7 February 2022

**ESR Horsley Logistics (SSD-10436-Mod-4)
Modification Report**

I refer to the Modification Application for the ESR Horsley Logistics Park-Mod-4 (SSD-10436-Mod-4).

Figure 3 Viewpoint Locations

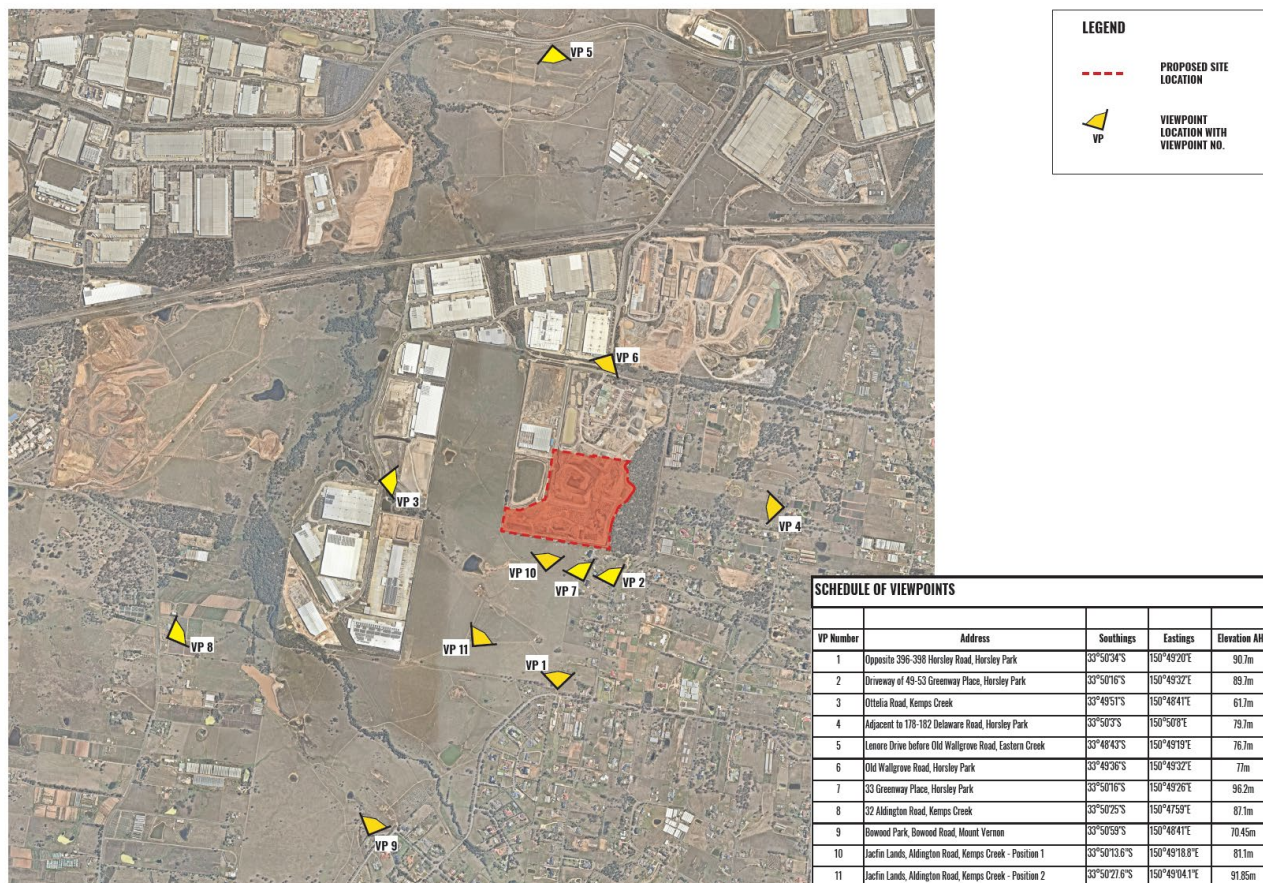
The Department notes the subject Modification Report refers to Mod 3:

- Section 6.2 Visual Impact provides a comparison between the current Mod 4 scheme and the Mod 3 scheme.
- The Department notes the Visual Impact Assessment (VIA) also compares the current Mod 4 scheme and the Mod 3 scheme.

As SSD-10436 Mod 3 was withdrawn, the Department requires that the Applicant revise all relevant sections of the Modification Report (including Section 6.2) and VIA and any other supporting report submitted with SSD-10436-Mod 4 to refer to the relevant modification application. Comparisons to the Mod 3 scheme must be updated.
